Sheringham Shoal and Dudgeon Offshore Wind Farm Extension Projects

Final Statement of Common Ground with National Highways (Revision E)

Document Reference: 12.22

▨ VEHICLE BODY SWEEP PATH (FORWARD GEAR)
 — VEHICLE CHASSIS SWEEP PATH

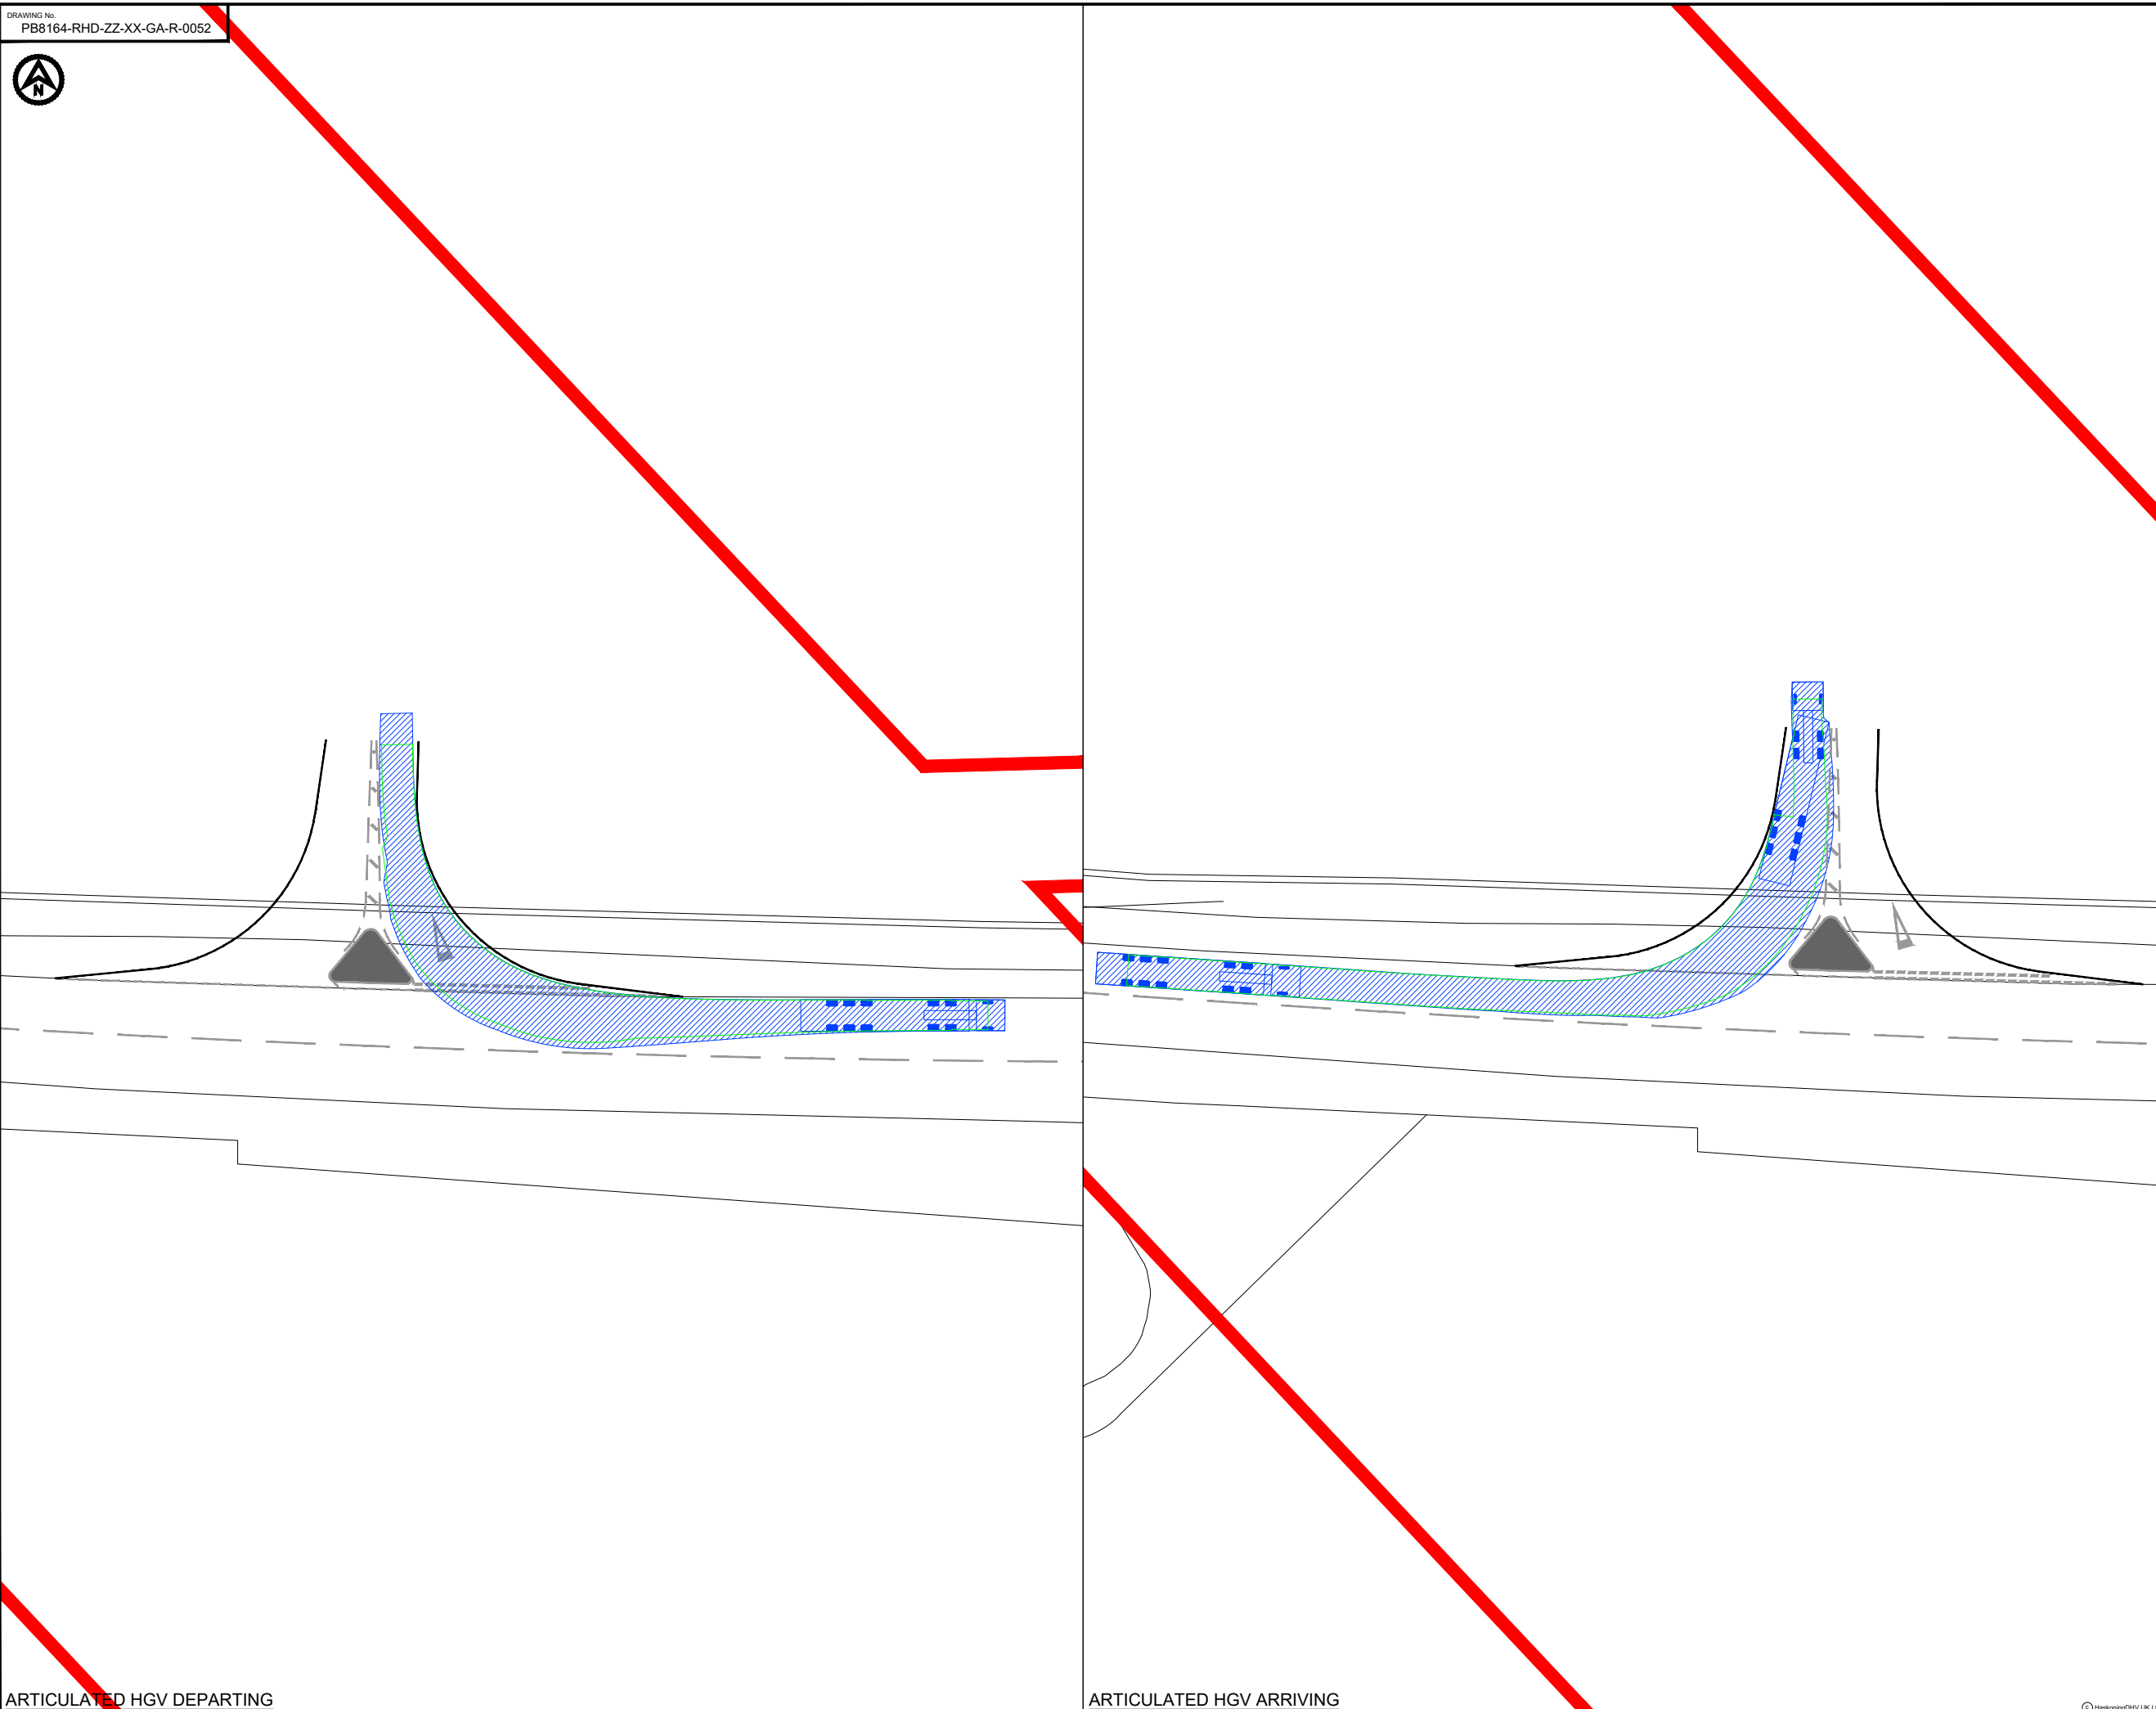
23	The outline design for an access off the A47 is appropriate, as presented in Annex 30 of the Transport Assessment [APP-268 and APP-269]	National Highways agree that the outline design for an access off the A47 (ACC47) is appropriate subject to Stage 1 and 2 Road Safety Audits being carried out post consent. Please note that this access is only usable until the A47 Tuddenham scheme starts construction, or if the A47 Scheme does not go ahead.	<i>Agreed</i>
EIA – Cumulative Impact Assessment (CIA) Conclusions			
24	Cumulative impacts assessment with other windfarms, as presented in Section 24.7 of ES Chapter 24 Traffic and Transport [APP-110], is appropriate based on currently available information and proposed mitigation, impacts are not significant in EIA terms.	National Highways agree that the cumulative impacts assessment with other windfarms, in relation to effects on traffic along the SRN, as presented in Section 24.7 of ES Chapter 24 Traffic and Transport [APP-110], is appropriate based on currently available information and proposed mitigation, impacts are not significant in EIA terms.	<i>Agreed</i>

29	The access concept design for access ACC47 is appropriate and that detailed access designs can be developed and agreed with National Highways prior to the start of construction, secured under Requirement 16 of the draft DCO [AS-009].	National Highways agree that the access concept design for access ACC47 is appropriate, subject to Stage 1 and 2 Road Safety Audits to be carried out post consent, and that detailed designs can be developed and agreed with National Highways	<i>Agreed</i>
